From: Amanda Scholes on behalf of Planning.Responses
Sent: 24 November 2020 09:52
To: Planning Scanning
Subject: FW: *EXTERNAL: FW: A/157/20/DOC - Land South of Water Lane, Angmering.

I refer to that CMP provided by Abbey Letchford Partnership dated 9th November 2020 Ref A290-R002/H.

Please find attached the amended Construction Management Plan for discharge of condition application A/157/20/DOC relating to Land South of Water Lane, Angmering.

Appendix C – Routing Plan

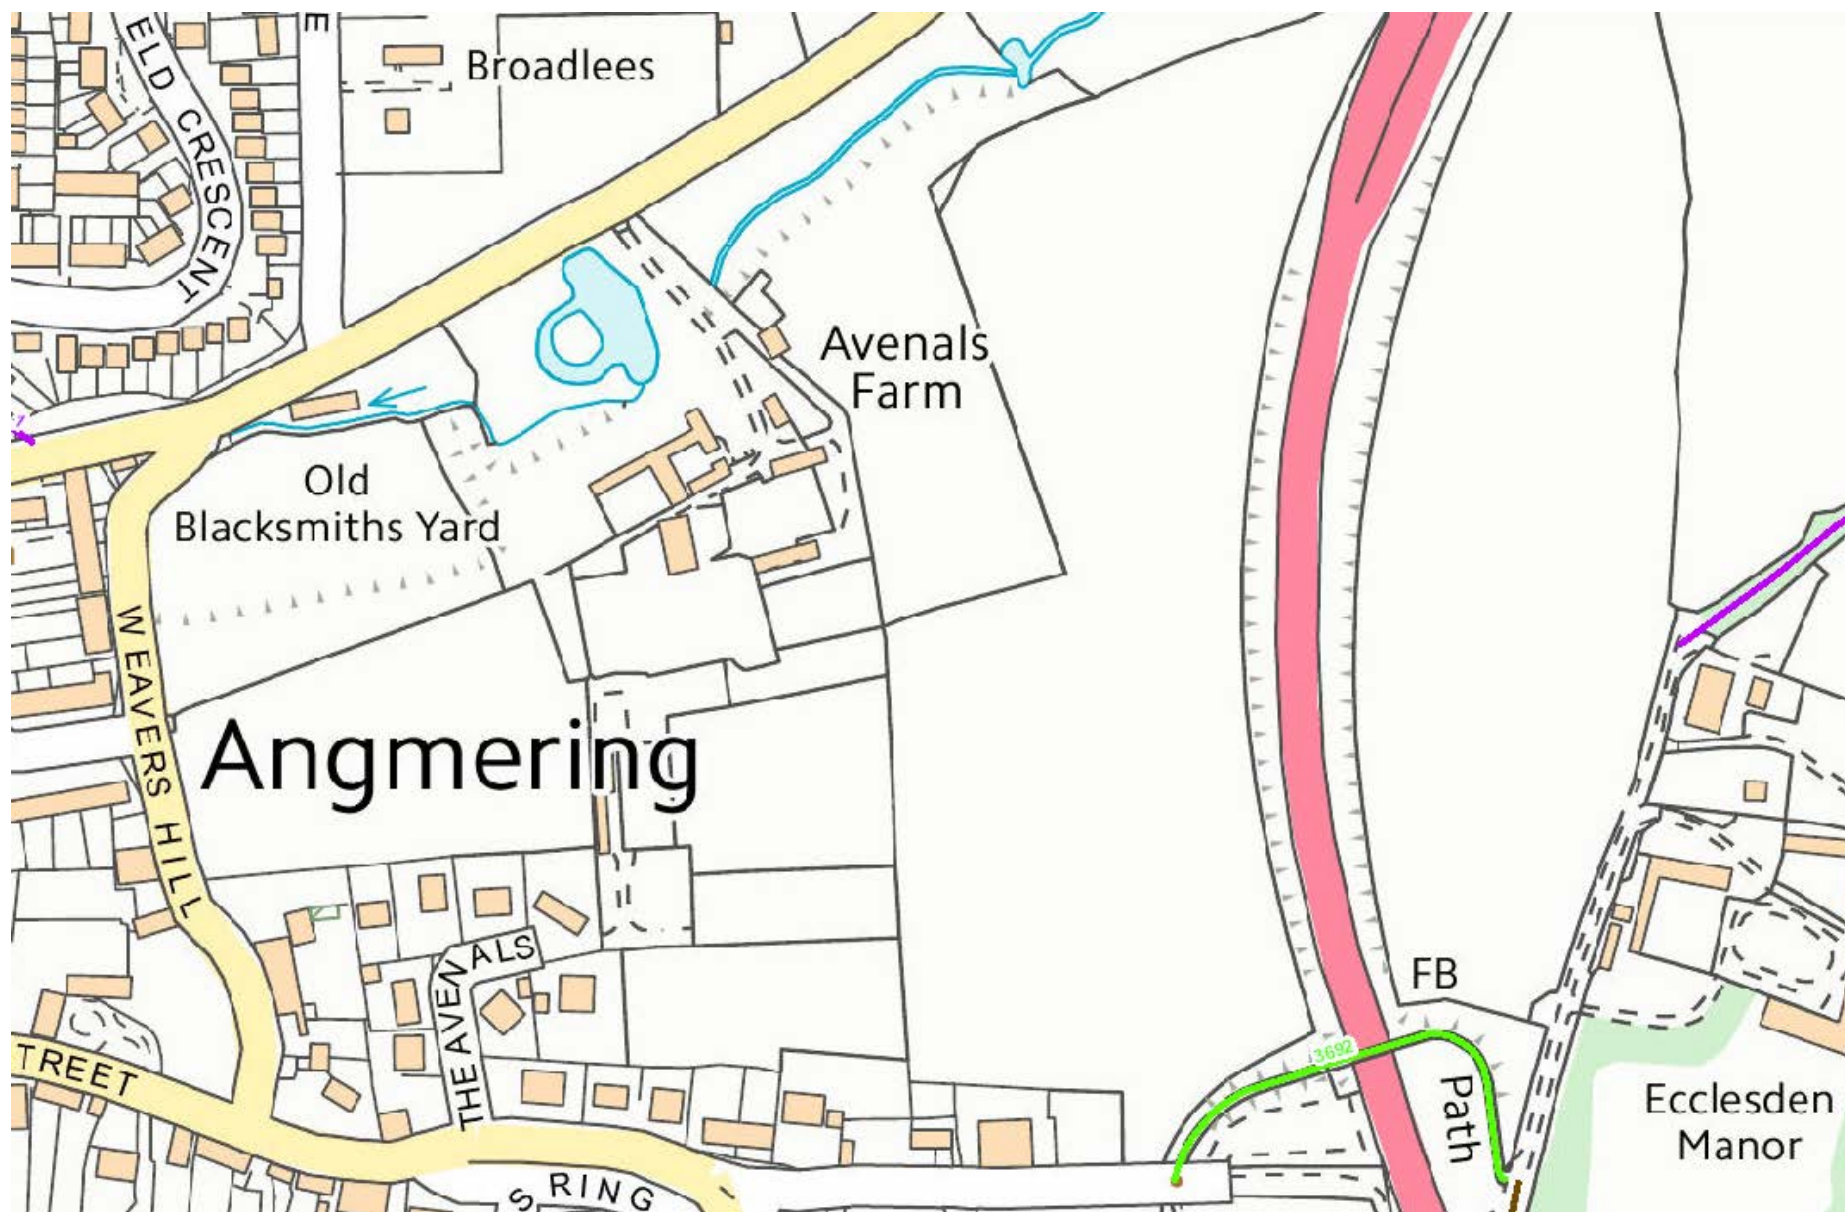
The above document revises the access road to initial site works, which will now be via Roundstone Lane and as first proposed, the High Street, Angmering. Although it continues to note no likely impact on the Highway Network, it fails to address the impact on residential units in the immediate vicinity of Roundstone Lane and the High Street.

Houses at the northern section of Roundstone Lane (at the High Street) and on the High Street, are close to these roads and likely to be detrimentally impacted by site traffic noise/vibration, most particularly from HGV's. These will pass close by, over potentially prolonged periods of time each weekday and over the 7 months to September 2021. The situation is exacerbated since this now restricted time frame is likely to mean that more HGVs will use this access per day/hour than previously described. This number of vehicles and their impact should be stated.

In conclusion, residential units at the top of Roundstone Lane and in particular the High Street, are likely to be detrimentally impacted by noise should this be the accepted access route. I would advise that The Construction Management Plan should allow for the provision of a temporary (or permanent) bridge allowing access to the site from Water Lane from the outset.

To follow on, the edits are contained within Paras. 2.1 – 2.7, with an amendment to the routing plan (Appendix C)
